TOWN AND COUNTRY PLANNING ACT 1990 FULL

Reference: H16-0061-22 **Date of Decision:** 8th March 2022
Applicant: Market Homes Ltd
C/O Swann Edwards Architecture Ltd
Black Barn
Fen Road
Guyhirn
PE13 4AA
Location: Land At Former Halmer Grange Grange Drive Spalding
Description: Erection of 2 detached dwellings

**SITE PLAN, LOCATION PLAN
& INDICATIVE STREET VIEW
(Dwg SE-1686 PP2000)**

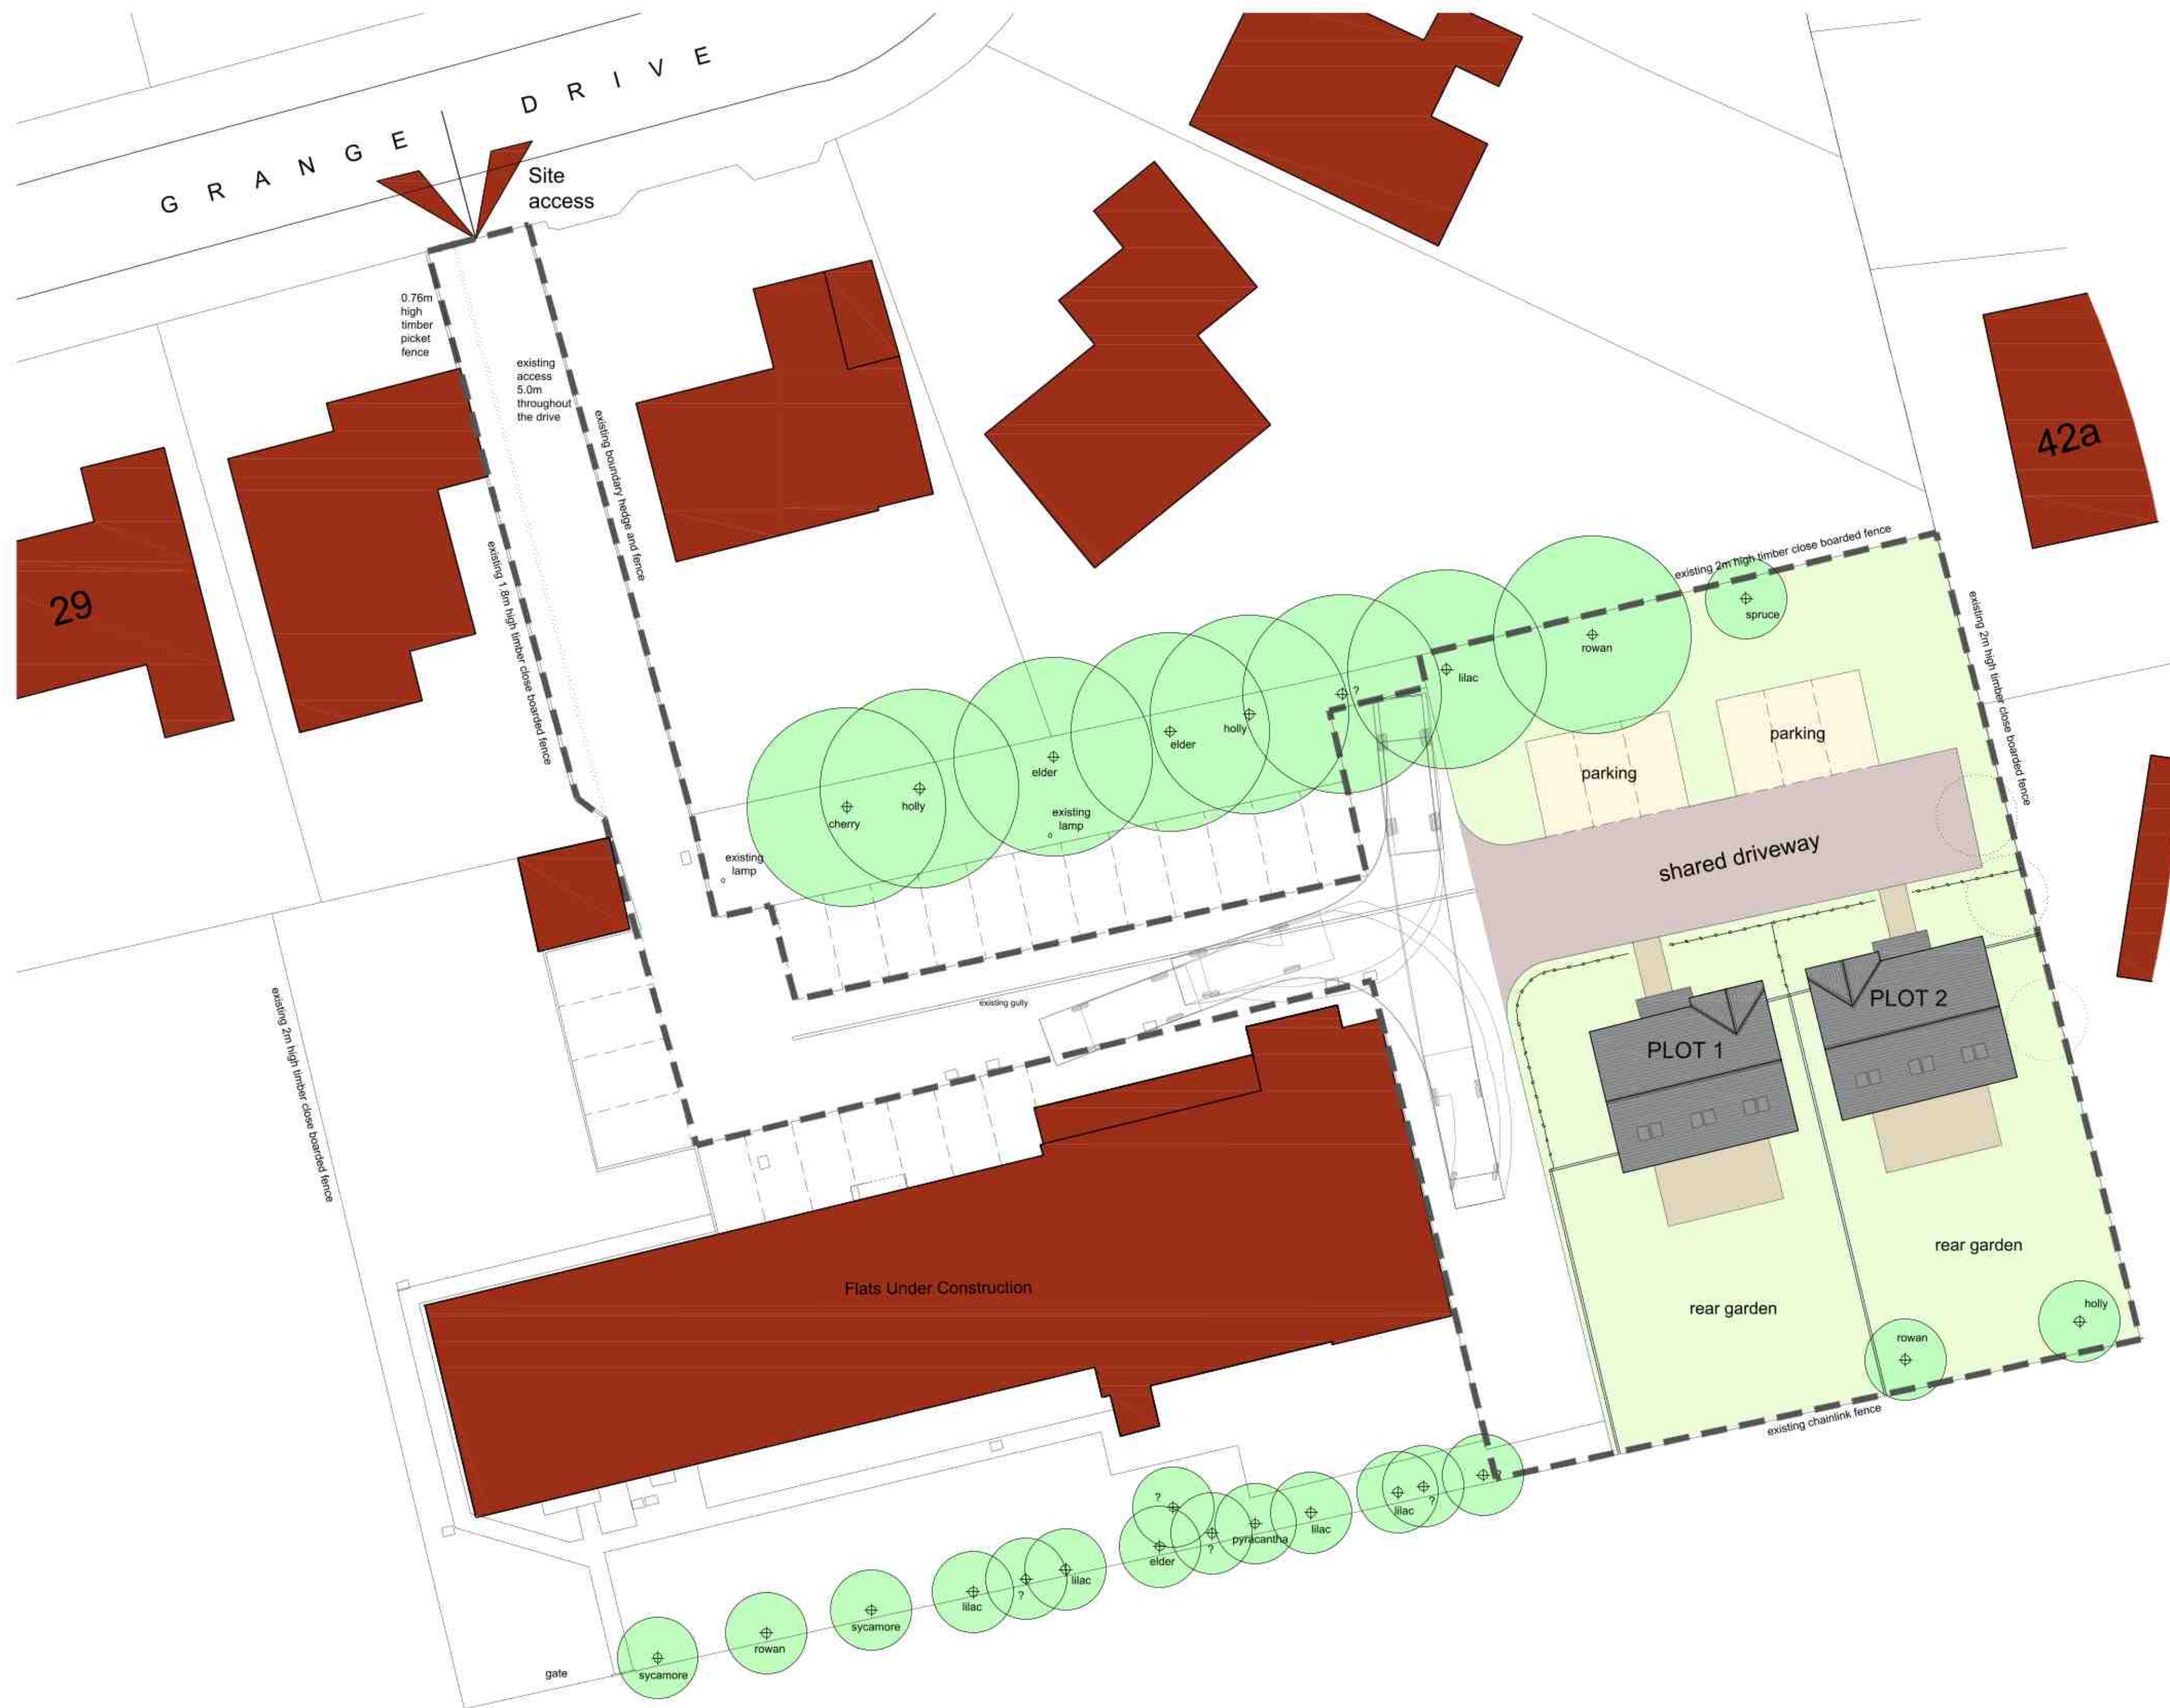
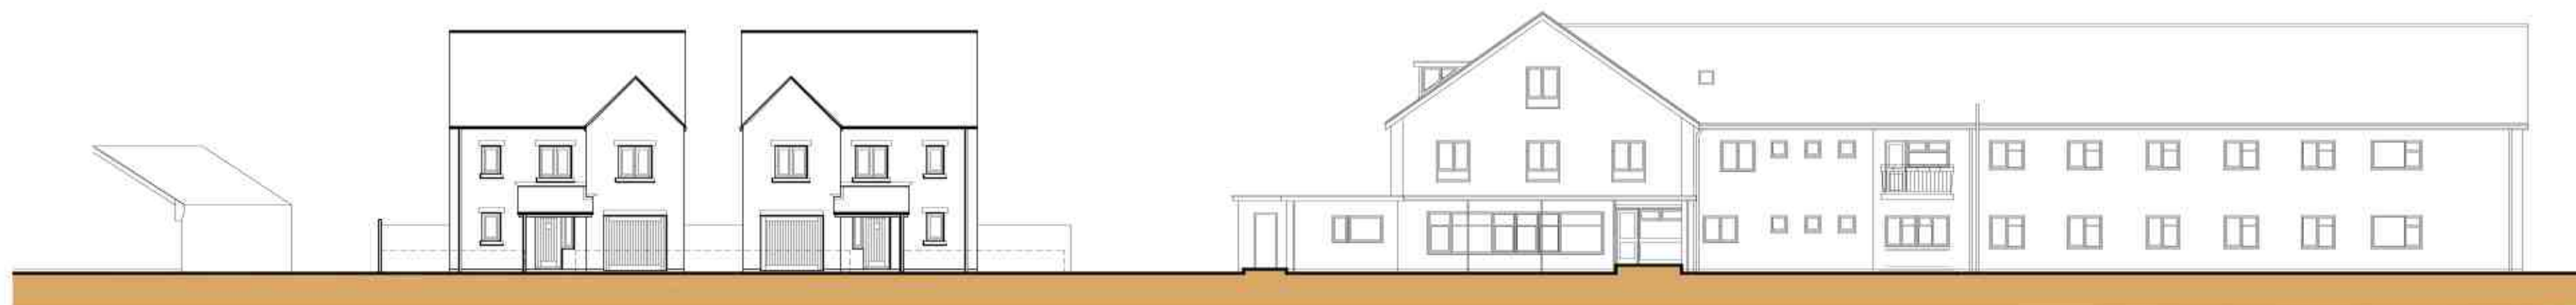
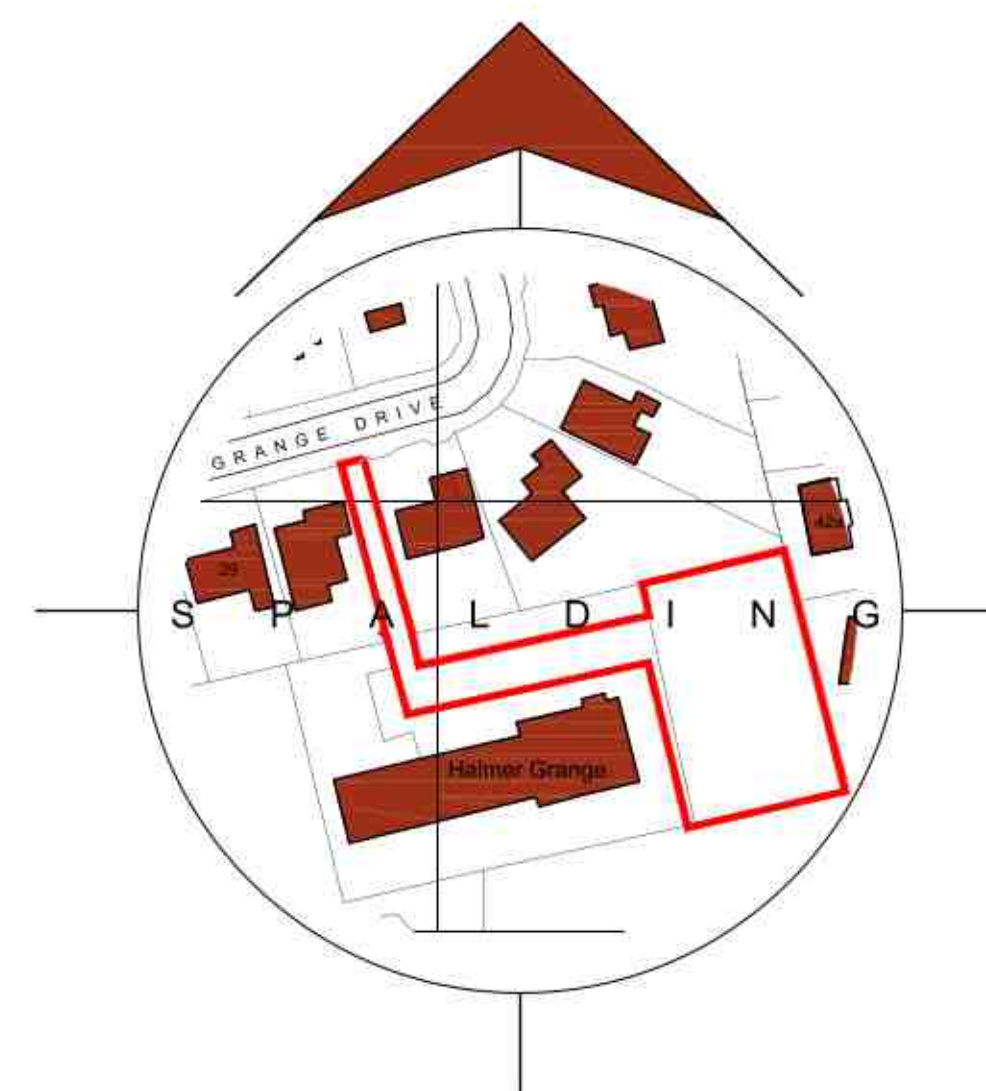
- 1 The proposed development would result in an increase in the number of vehicular and pedestrian movements taking place across the site (i.e. including Grange Court to the west), with the source of the noise being spread across its full extent rather than being focussed in the flats and associated parking areas. The dwellings would introduce a different type of noise and activity with the potential for families living within the site. The access, whilst LCC Highways have no objections, would still remain the focal point for all movement through the site and the additional two dwellings would generate travel movements over and above the current flats. These movements will all impact upon the occupiers of the flats and upon immediate neighbours (in particular those either side of the access off Grange Drive) and will intensify activity and disturbance on an area of land where there is already a high level of development. Although the additional movements and activity associated with the dwellings may not be considered significant in their own right, when added to what is already in existence the cumulative impact would be significant. It is therefore considered that the proposal would create a detrimental impact upon the residential amenity of the adjacent occupiers.

- 3 The proposal does not satisfactorily accord with South Holland District Council's guidance note entitled 'Private Drives - Waste Vehicle Collection Service', which seeks to ensure appropriate arrangements for refuse and recycling collection. In particular, the distance from the curtilage of either dwelling to the public highway far exceeds the 30m carrying distance set out within and it would also not be appropriate in amenity terms for occupants of these dwellings to be depositing refuse and recycling sacks outside unrelated properties which do front the public highway. In addition, it is highly unlikely that the application site would be considered a suitable candidate by the Waste Services department for an indemnity to be entered into for the Council to enter the private drive and collect from the property.
